**WELWYN HATFIELD BOROUGH COUNCIL
DIRECTORATE OF STRATEGY AND DEVELOPMENT**

DELEGATED APPLICATION

Application No: 6/2016/1452/EM
Location: 12 Rooks Hill, Welwyn Garden City, AL8 6ET
Proposal: Erection of two storey, single storey rear extension and alterations
Officer: Ms L Hale

Recommendation: Granted

PROPOSED REAR ELEVATION 1:100

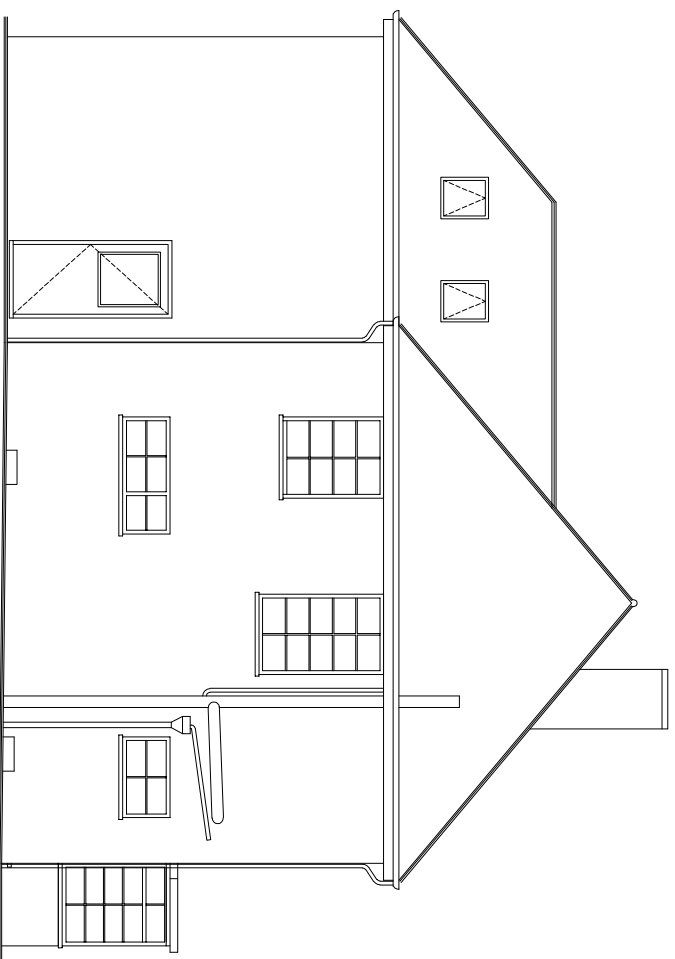
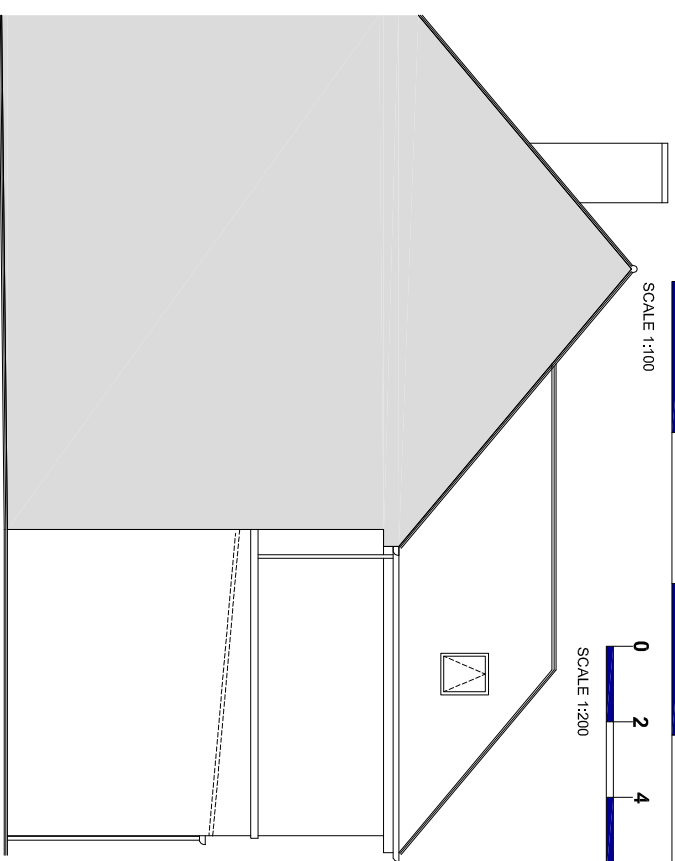
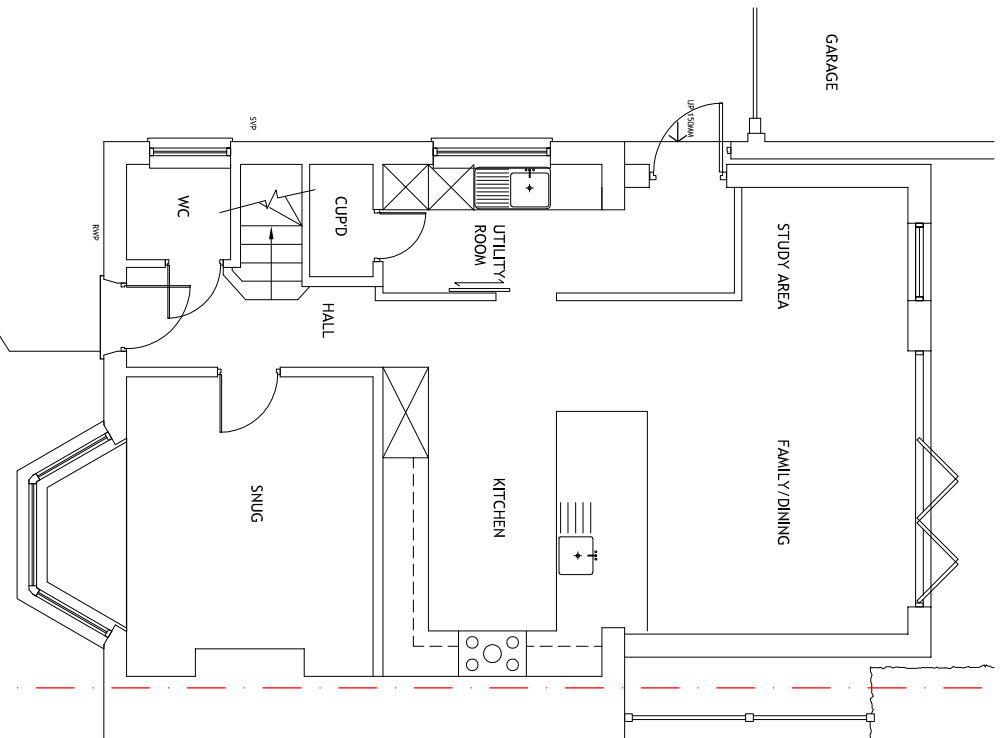
The proposal seeks estate management consent for a part two storey (hipped roof design) and part single storey rear extension (with a flat roof, parapet wall and roof light). The proposed development would be set in from the boundary shared with No.10 Rooks Hill by approximately 0.4 metres at single storey and 2.5 metres at first floor level. It would extend 6.5 metres wide and 4 metres in depth off the rear wall, and 3.2 metres in height.

No.10 Rooks Hill adjoins the host dwelling. No.10 benefits from an existing rear conservatory. The proposed development would be set in from the boundary shared with No.10 Rooks Hill by approximately 0.4 metres at single storey and 2.5 metres at first floor level. It would extend 6.5 metres wide and 4 metres in depth off the rear wall. Given the modest height of the single storey element, and distance between the first floor element, the proposed extension is not considered to result in any loss of residential amenity in the form of loss of light, loss of privacy or overbearing impact.

PROPOSED FIRST FLOOR PLAN 1:100

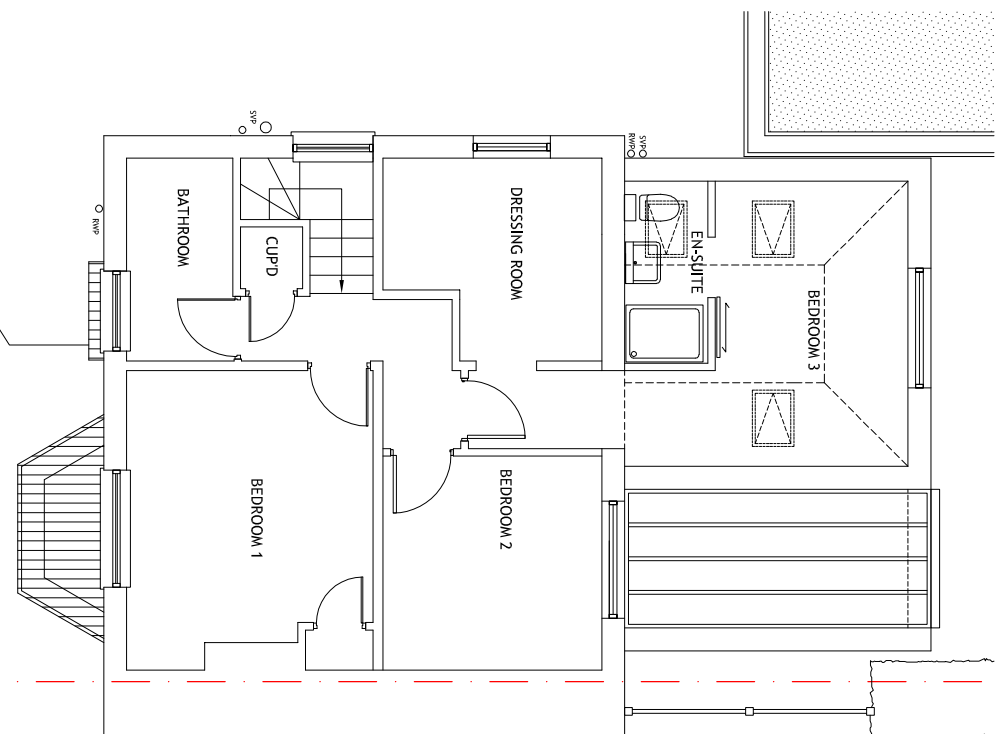
A first floor window to the east elevation is proposed to accommodate a bedroom. This would overlook No.14 and therefore should be conditioned as obscure glazed and non opening from a height of 1.8 metres from the internal ground floor of the room to prevent overlooking or loss of privacy.

7. The first floor window to the east elevation of the proposed building shall be glazed with obscured glass and shall be fixed so as to be incapable of being opened below a height of 1.8 metres above floor level, and shall be retained in that form thereafter.
